CITY OF ALBUQUERQUE

**Re: Christian Brothers Automotive
Erosion and Sediment Control Plan
Engineer's Stamp Date 11-21-17 (D20E010B)**

SILT FENCE

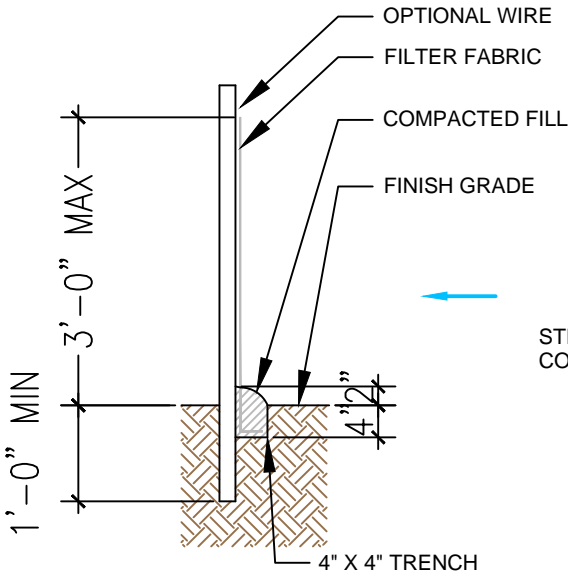
1. A sediment BMP (mulch sock/wattle, etc...) should be placed in the Paseo Del Norte ROW west of the disturbance.
2. In the future, please include the pole size and pole spacing on the silt fence detail.
